STATE OF NORTH CAROLINA
DEPARTMENT OF TRANSPORTATION

Division Six - District Two
Harnett County

SUBJECT: Encroachment Agreement for the installation of a 2" sewer line on SR 2232.

MAP OF CORRECTION
TO ADD SEWER EASEMENT

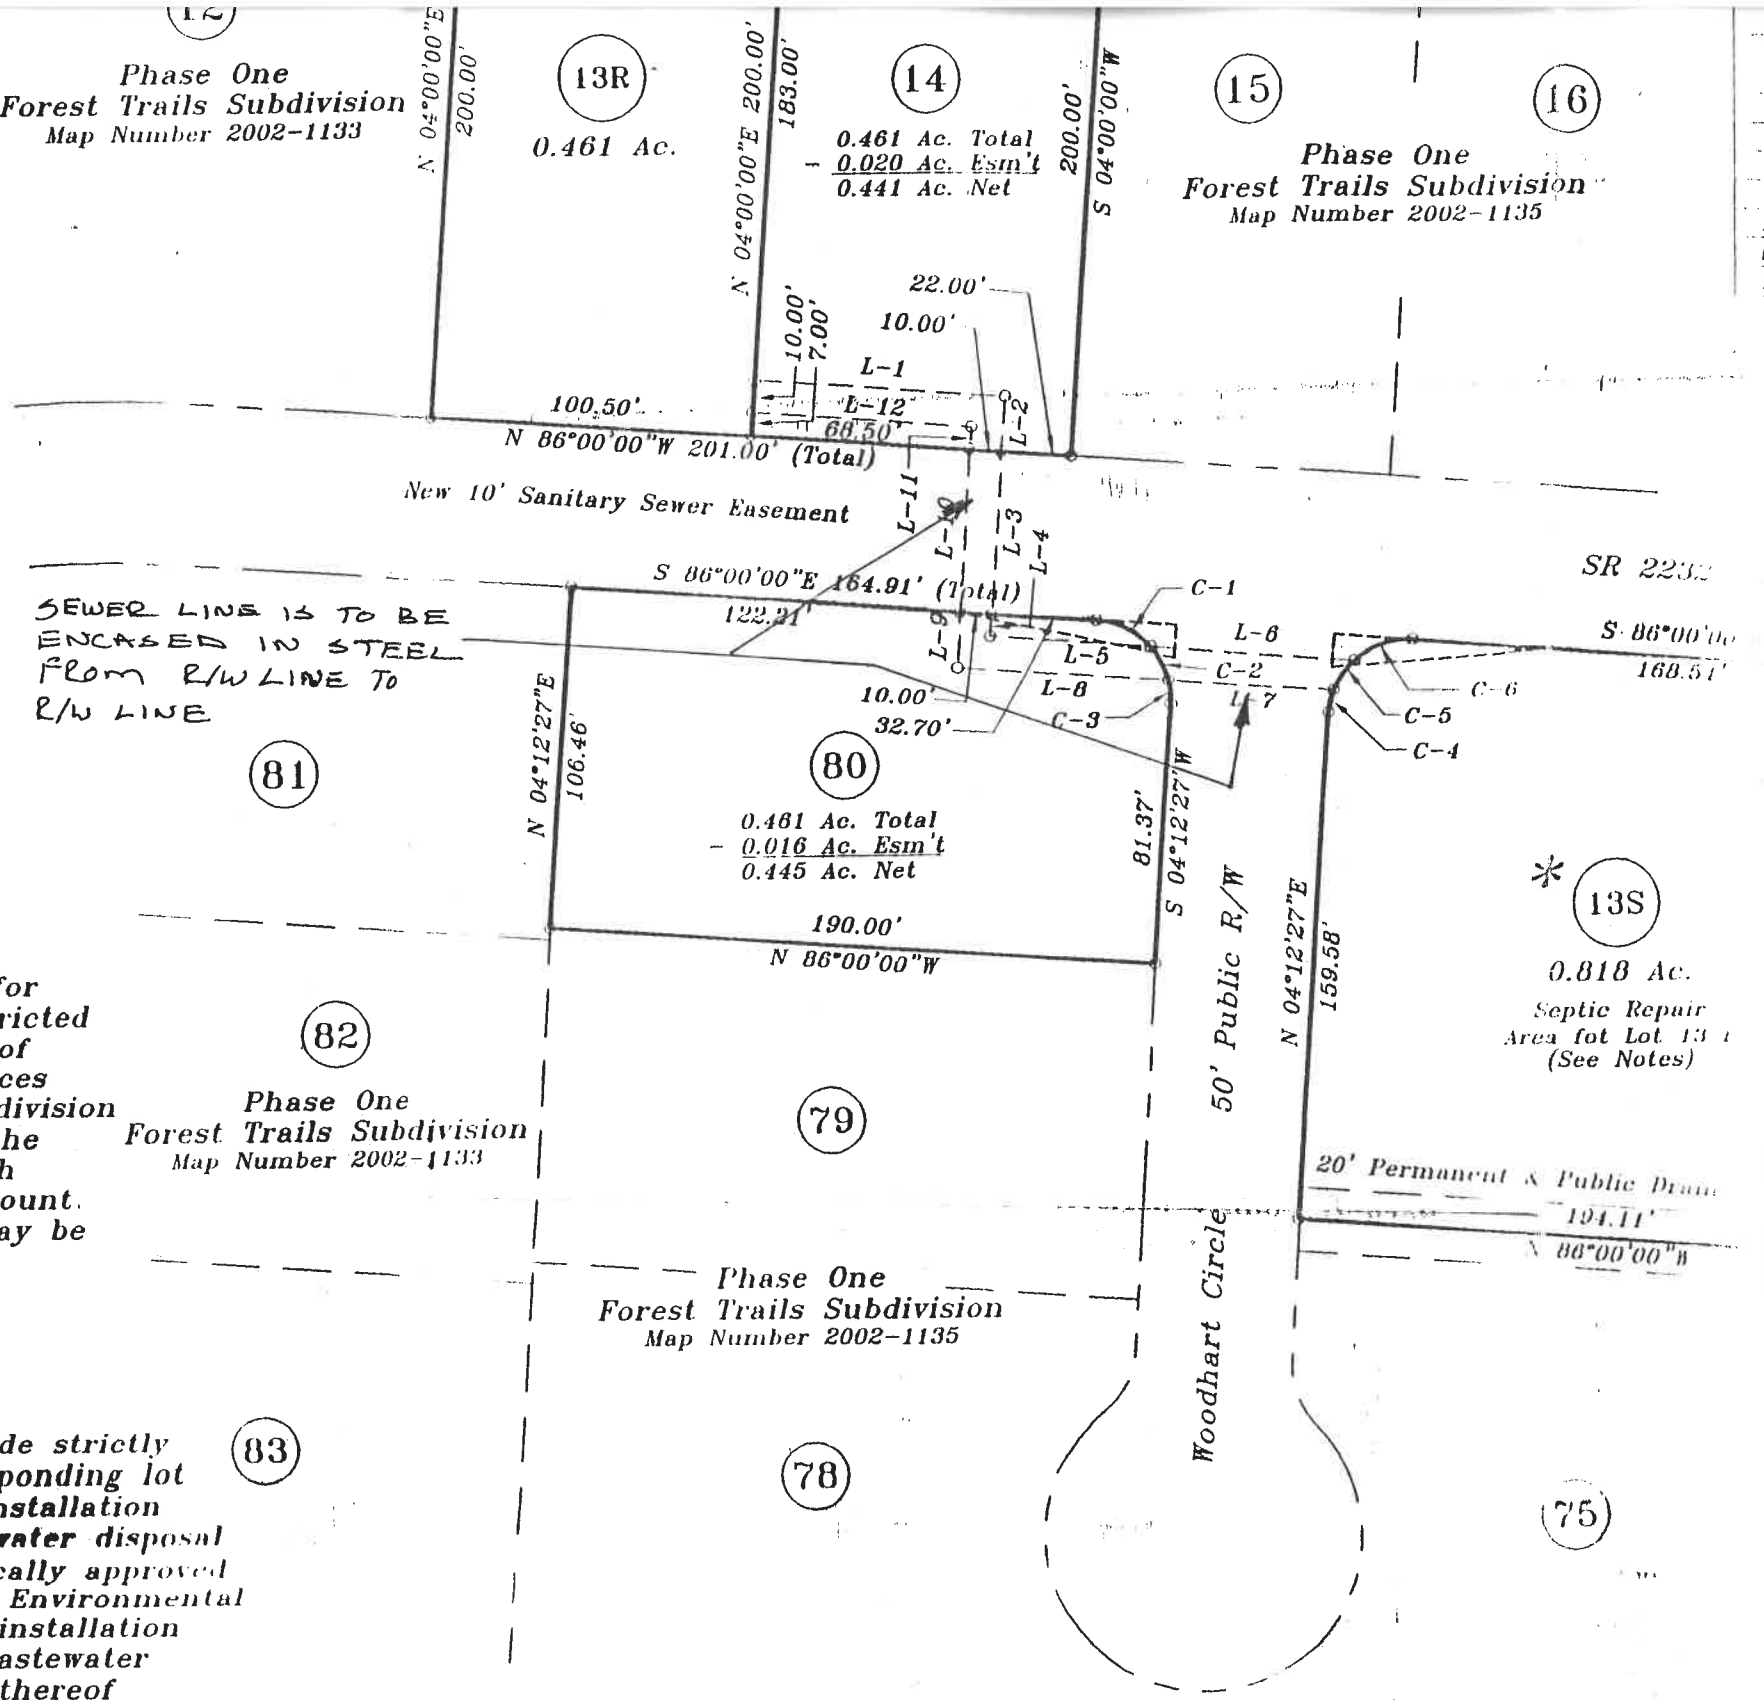
9. The 2" PVC Schedule 40 sewer line shall have a steel encasement from right-of-way line to right-of-way line on SR 2232. Since Woodhart Circle is to be added to the state system, the sewer line is to be encased from right-of-way line to right-of-way line on this road as well.

10. The encased sewer line is to be placed a minimum of 18 inches below the flow line of the existing ditches.
11. No material storage shall be allowed along the shoulders of the roadway, and during non-working hours, equipment shall be parked as close to the right of way line as possible and shall be properly barricaded so that no equipment obstruction shall be within the Clear Recovery Area.
